*Telephone Enquiries:
Wal Mills 4980 0299
Infrastructure Planning
Please Quote File No:
PSC2007-4309*

**Re: Queensland-Hunter Gas Pipeline
Your ref MP 06_0286**

W Mills
Strategic Engineer
20 October 2008

SURVEY EFFORT MAP 2.02 -
LOWER HUNTER VALLEY
(East Maitland - Largs)

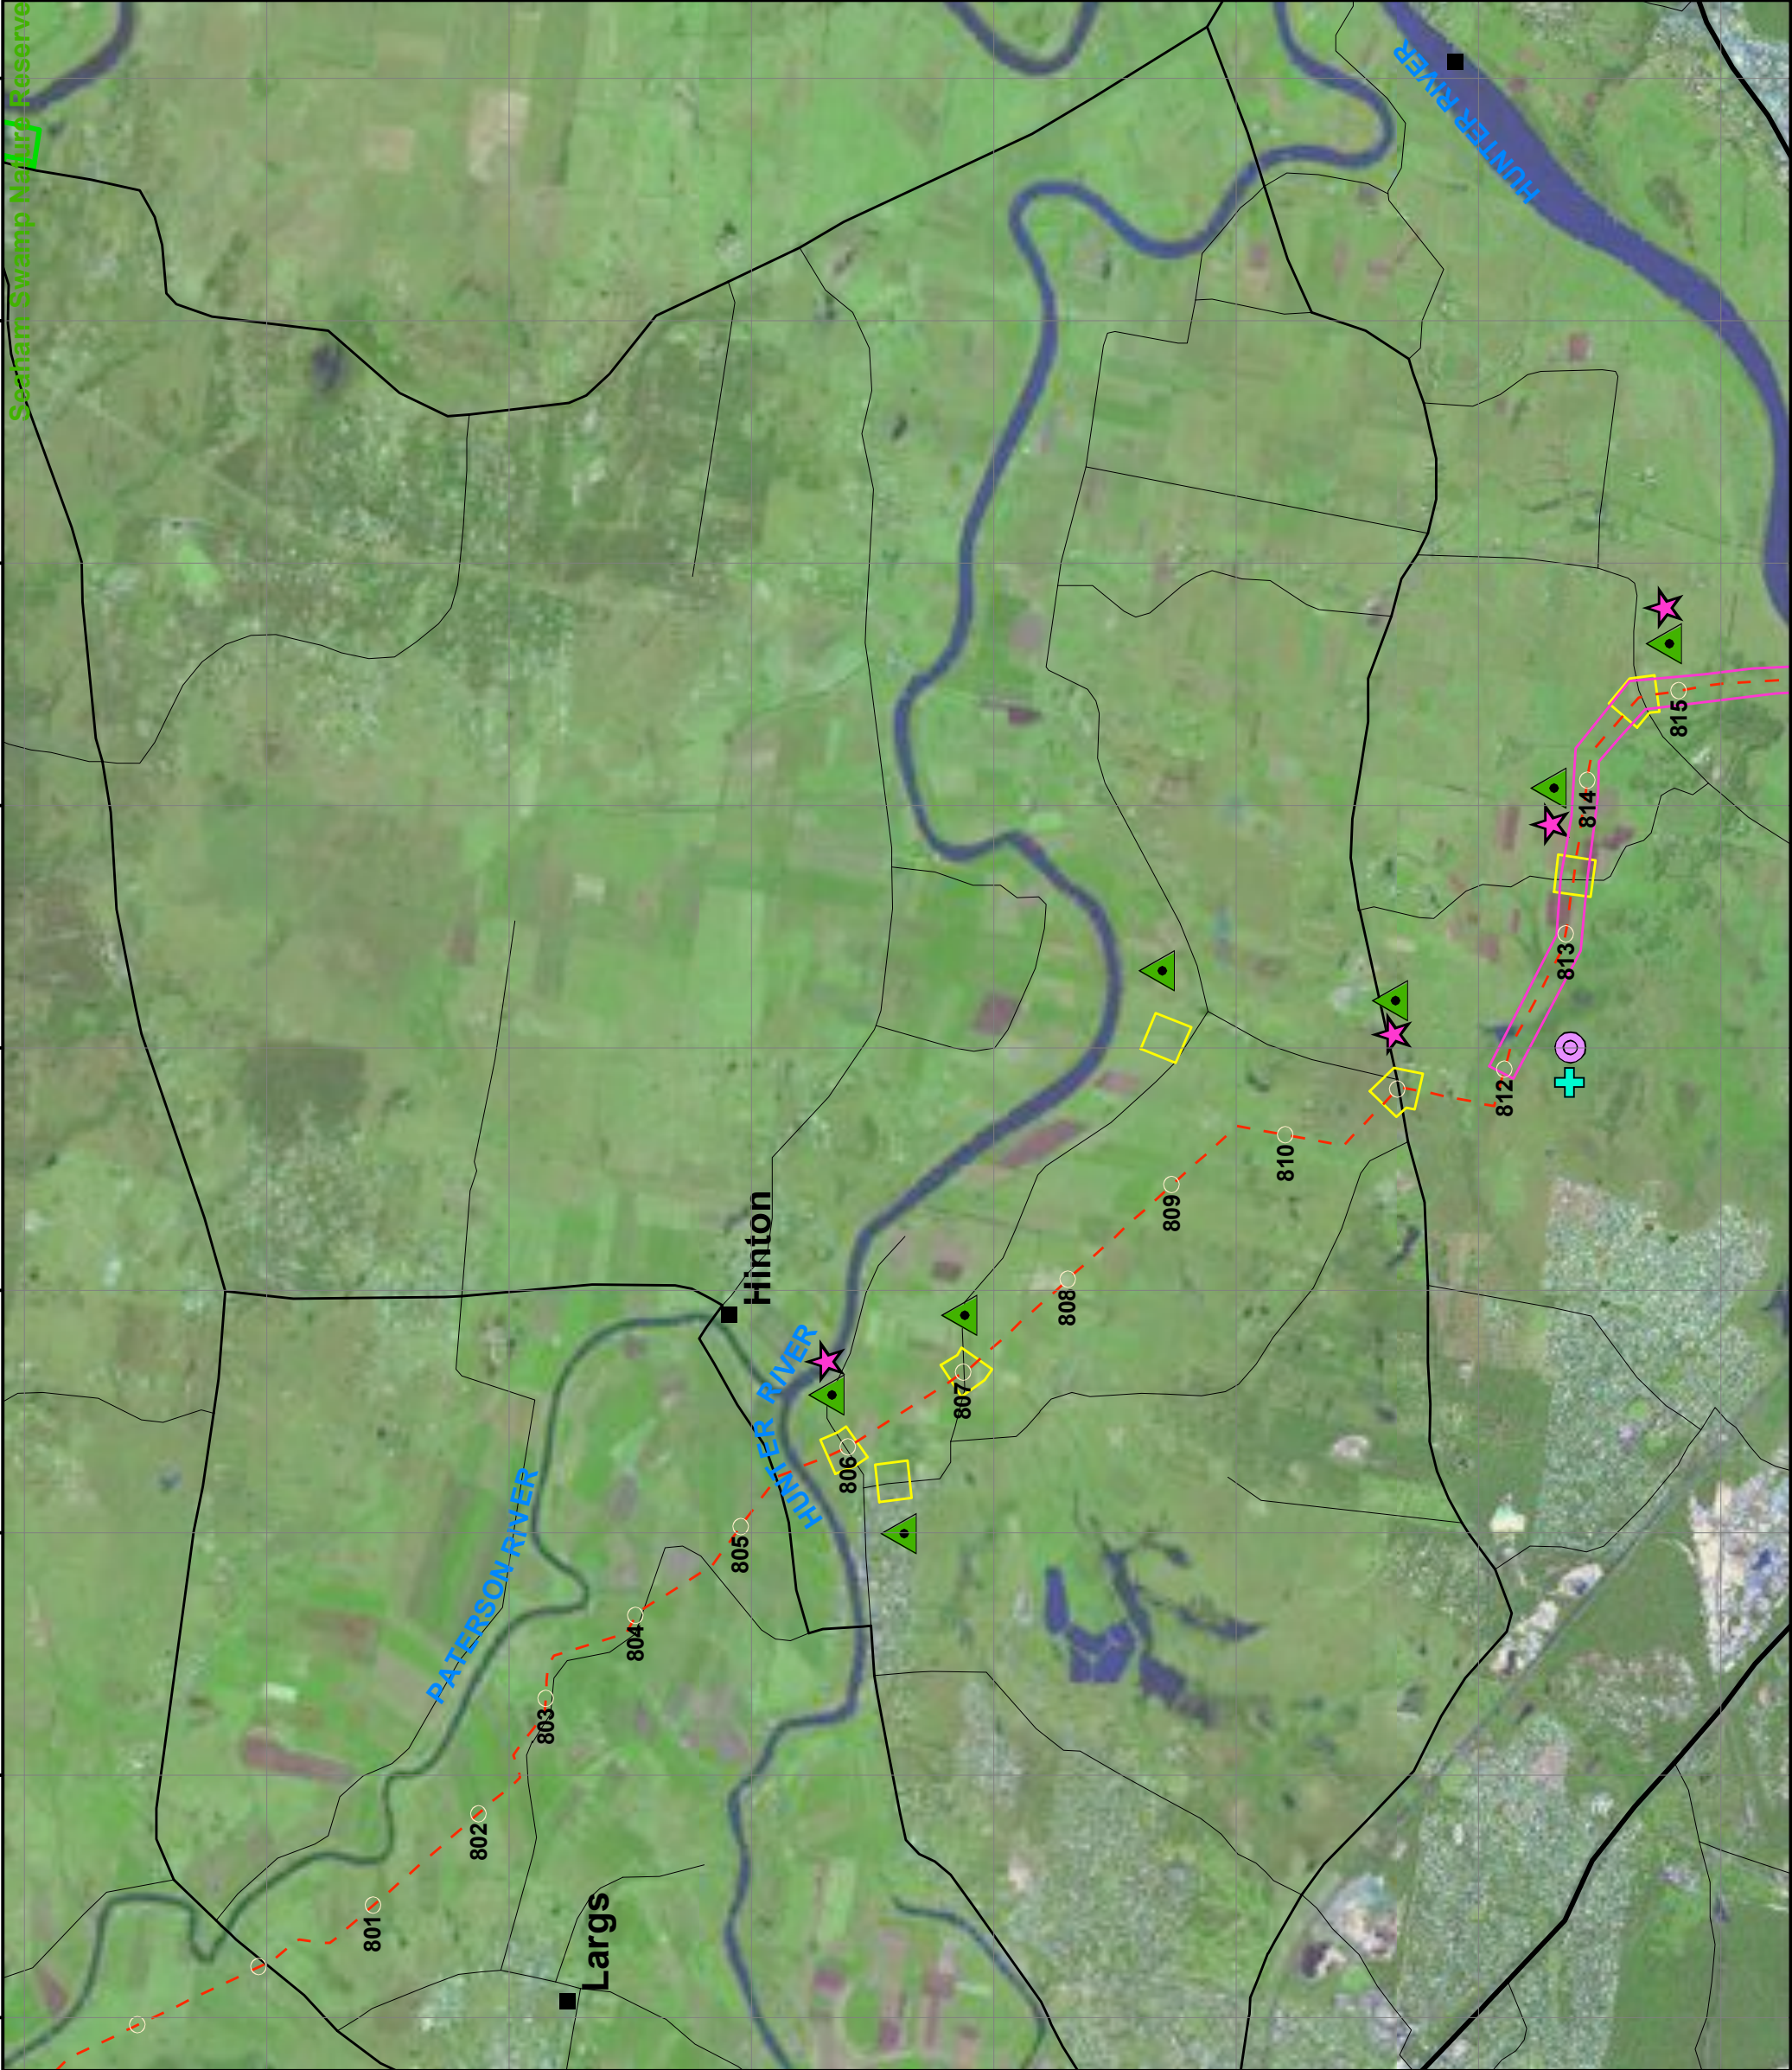
As the pipeline crosses the Hunter River into Port Stephens there is an area of Swamp Oak Floodplain Forest and as the pipeline leaves the Port Stephens LGA, again crossing the Hunter River, there is an area of Coastal Saltmarsh. The presence of these EECs will need to be ground truthed however there is presently no mention of them in the Environmental Assessment. If these communities do exist on site the disturbance to these communities should be avoided and the Environmental Assessment should define an appropriate buffer so that these EECs suffer no adverse effects from any adjacent works. The same management measures as listed in the EA for EECs in other LGAs should also be applied. The assessment should also detail the specification, including the location, of any remediation activities to reduce the impact to threatened species.

The proposed route comes in close proximity, or perhaps even crosses, a SEPP 14 wetland as the pipeline leaves the Port Stephens LGA. Disturbance of this wetland should be avoided and the Environmental Assessment should define an appropriate buffer around these wetlands to ensure no adverse effects, especially in relation to changes in hydrology, are experienced.
